## Portishead Branch Line (MetroWest Phase 1)

**TR040011**

**9.34 ExA.CWR.D5.V1 – Applicant's responses to Written Representations submitted for Deadline 4**

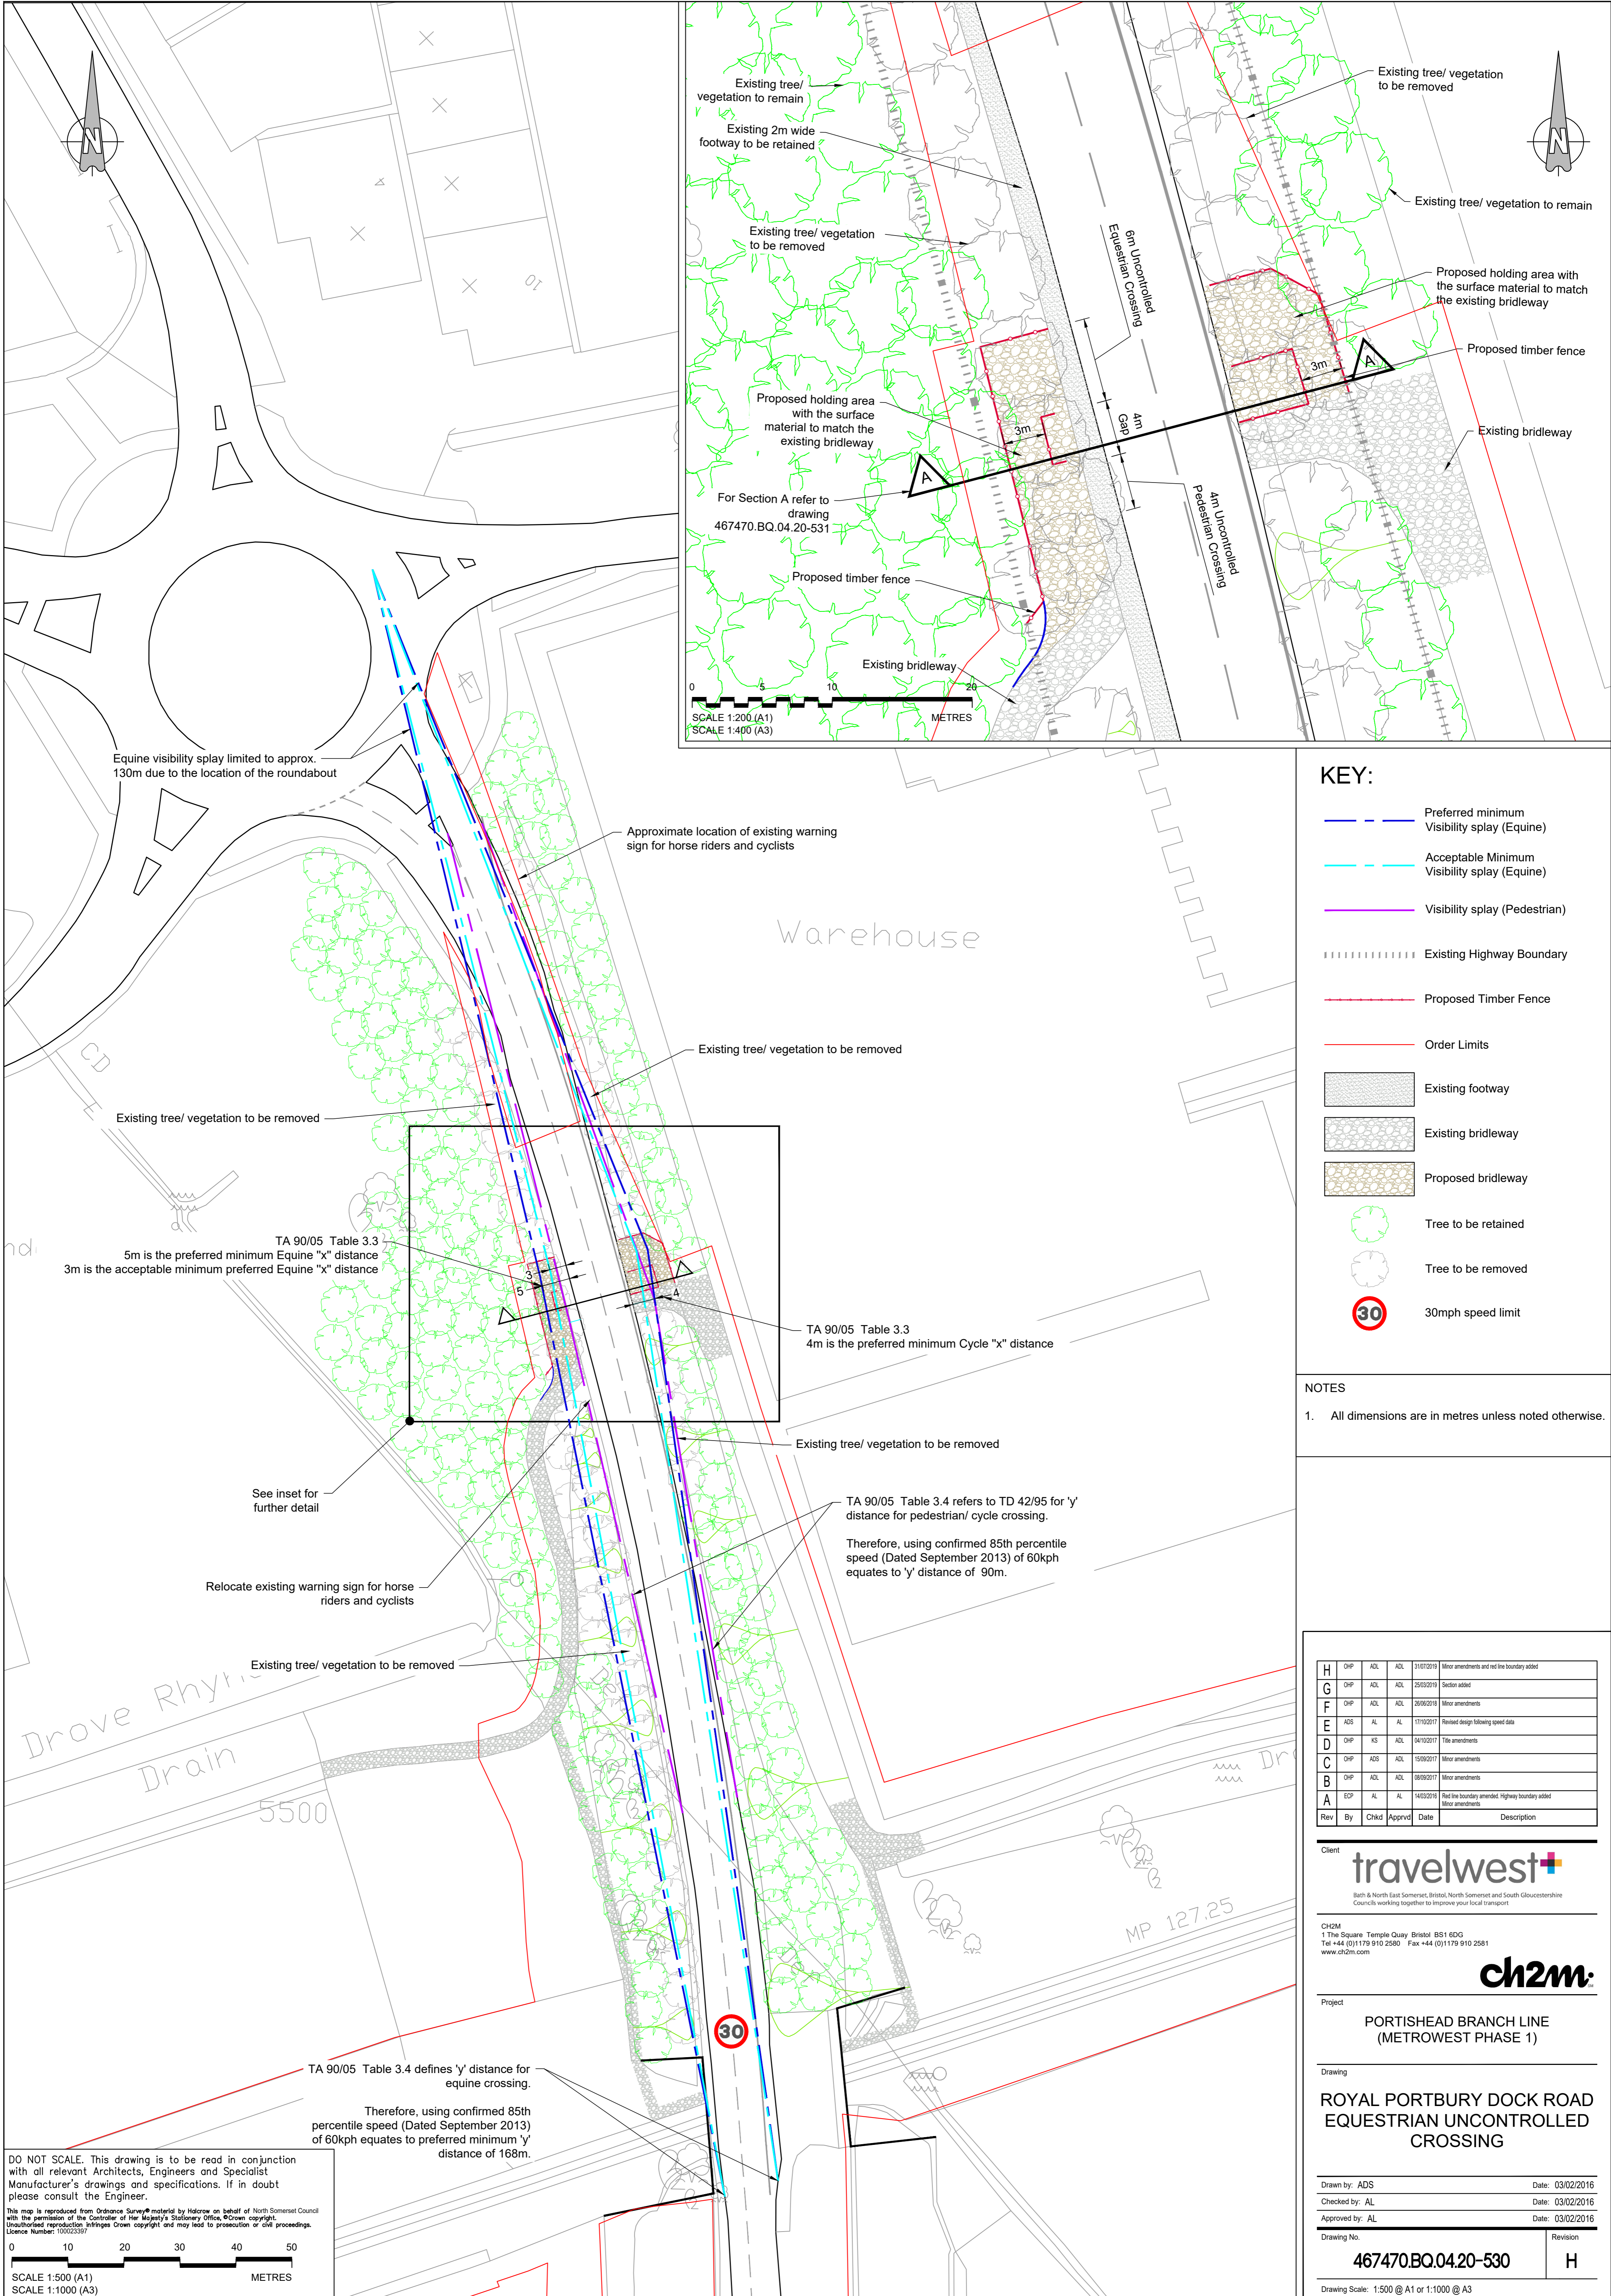
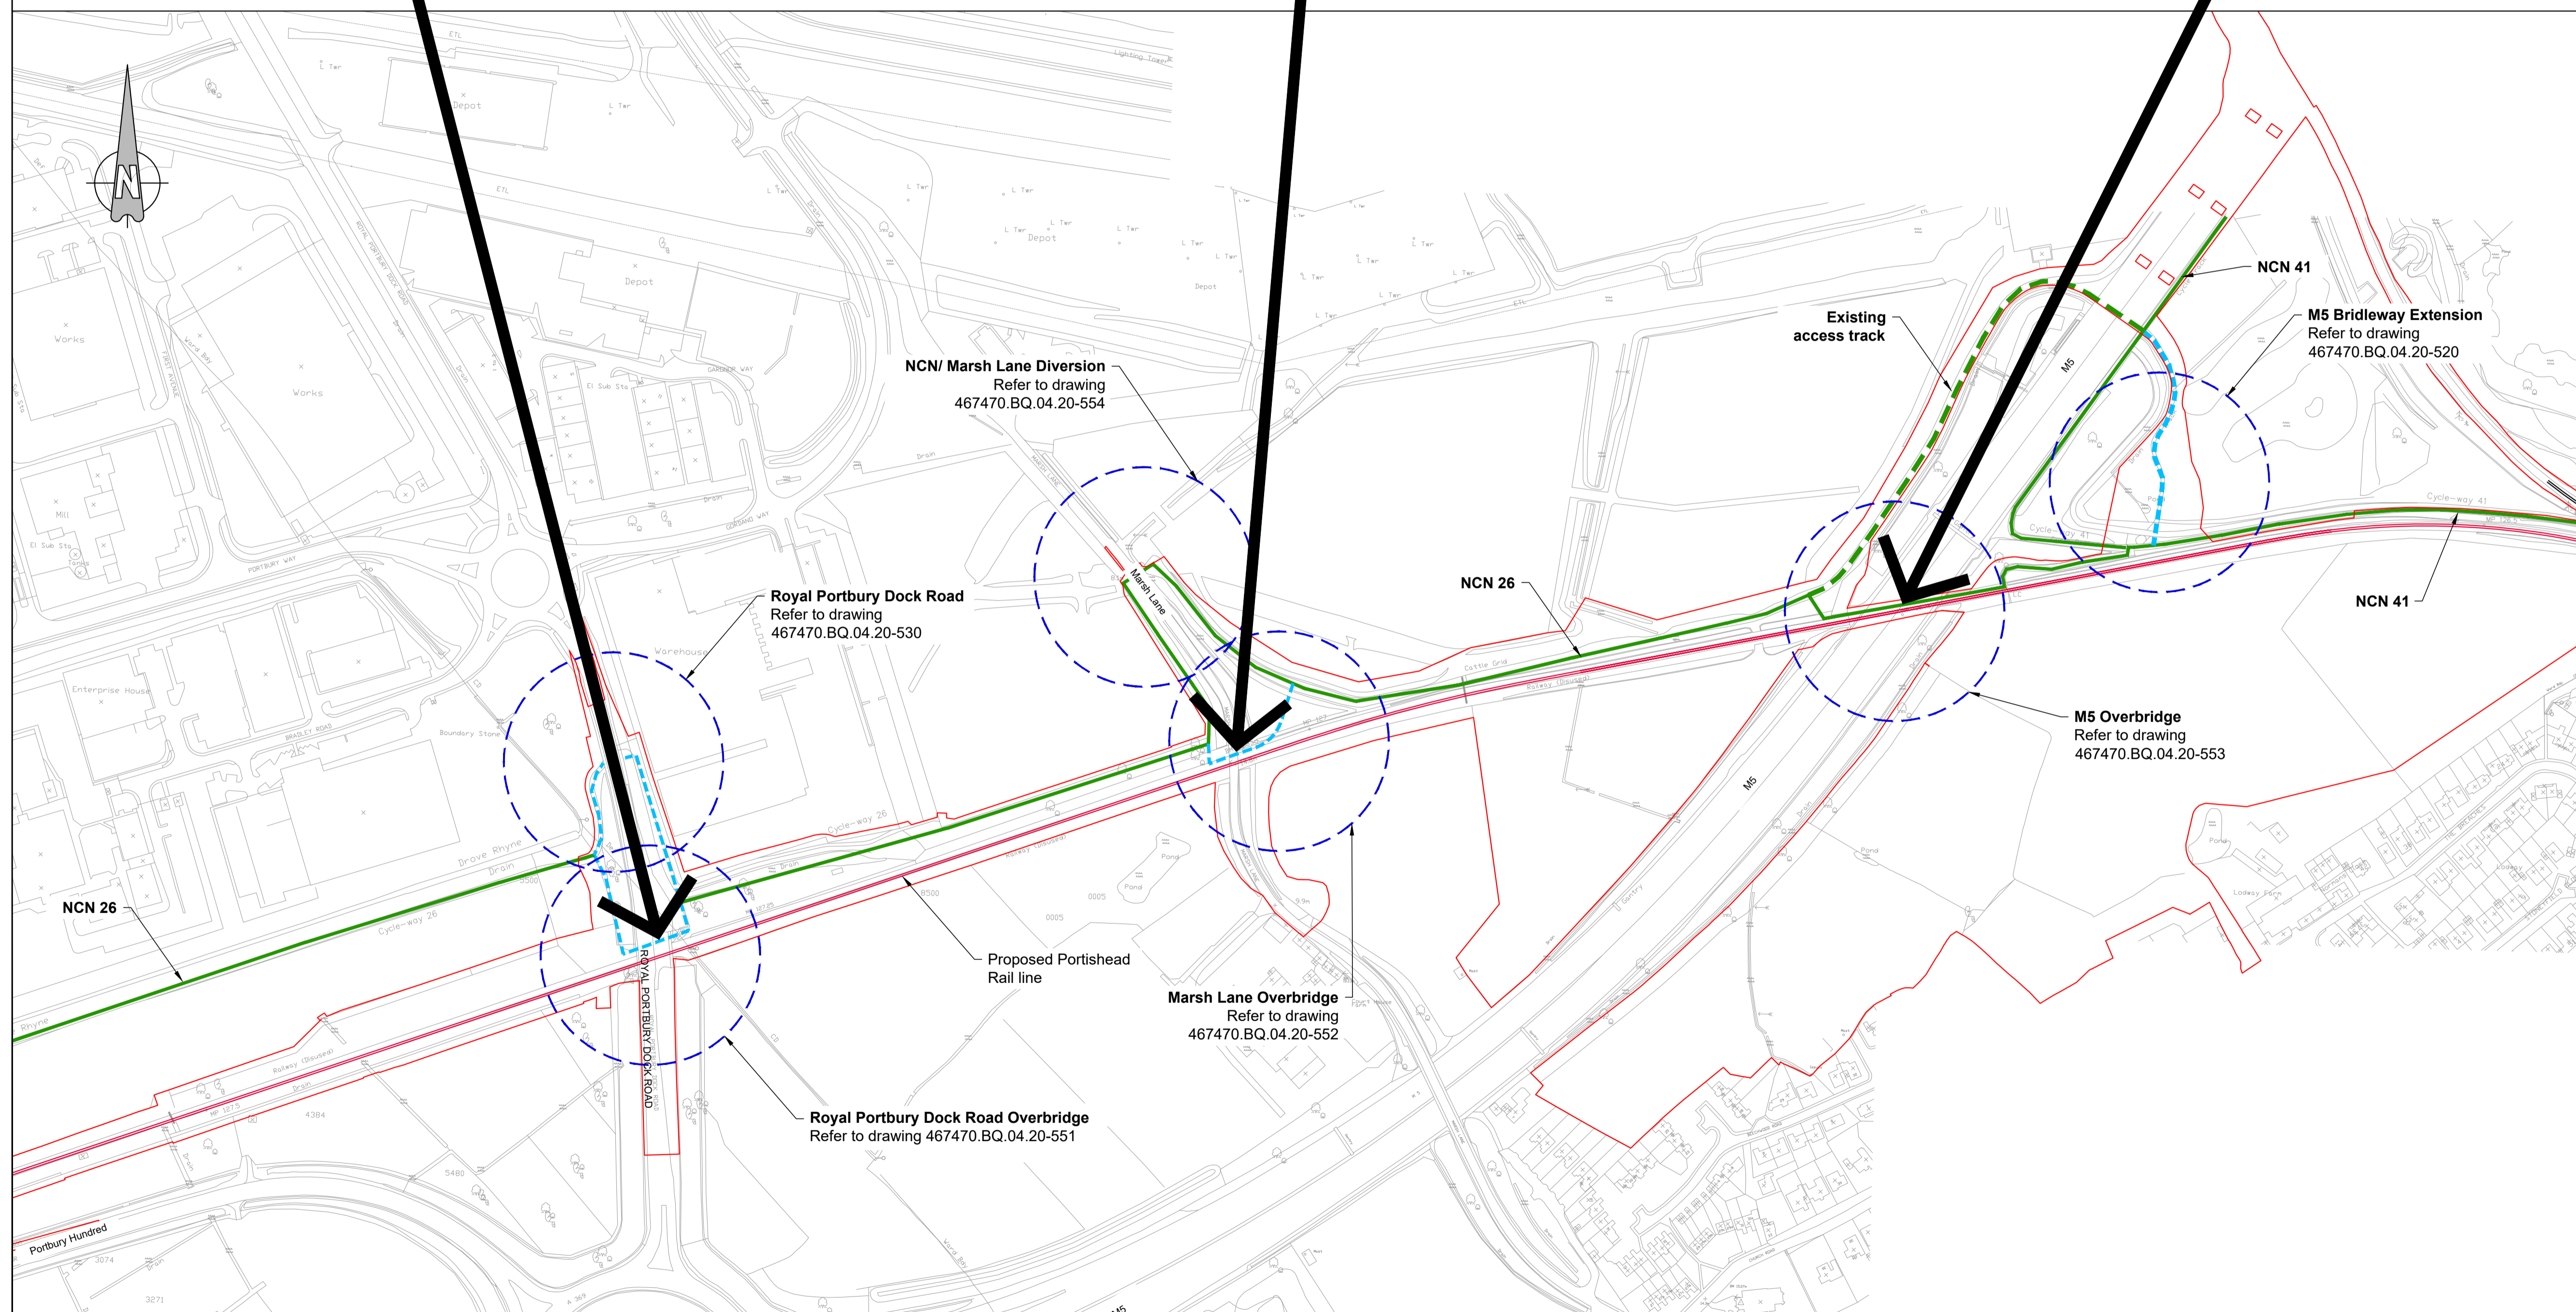
001106-D4-001	Bill Ovel on behalf of Pill & Easton-in-Gordano Parish	Ref: DCO, Section 2.37 National Cycle Route (NCN) Temporary and Permanent Works Plan Currently, the disused railway and a permissive route run side-by-side through the M5 overbridge to the west of Pill. This permissive route is heavily utilised by pedestrians and cyclists on national cycle way NCN 26 and, occasionally, by horse riders. The bridge is effectively a short, narrow tunnel about 50 metres long. It is believed that, once MetroWest construction is complete, the intention is for the permissive way to be reopened. It is recognised that an alternative, longer route, bypassing the overbridge to the north, will be provided by the proposed re-routing of the bridleway bridleway. However, if the pedestrian/cycle route is to be retained in close proximity to the operational railway, then a significant health and safety issue would result for any people and	<p>There is no proposal for an acoustic barrier. It is unlikely such a barrier would be effective.</p> <p>The route is permissive and if it transpires that the noise of passing trains is not acceptable then the licence will be terminated and all users will instead be diverted north along the existing bridleway and Work No 18.</p>

Ref no.	Party	Response	Applicant's response
		animals who were on the path inside the M5 overbridge when a train transited under the bridge due to the deafening noise levels that would inevitably be generated. The length of the bridge is such that it might not be possible for many people to get out of the "tunnel" in time even if a train was heard to be approaching. Accordingly, if the permissive route is to be retained, then an acoustic barrier should be installed for the full length of the overbridge to shield pedestrians, cyclists and animals from the noise caused by the passage of the train.	
001106-D4-002		Of course, an alternative solution would be to close that section of the permissive route and oblige all users to use the diverted bridleway but that is not shown as being the case in the DCO. Of course, it would be necessary to ensure that the re-routed bridleway would be compatible with simultaneous use by pedestrians, cyclists and horse-riders.	See response above. The proposal is a bridleway for Work No 18, without segregation. This would reflect the current bridleway from Marsh Lane to the M5.
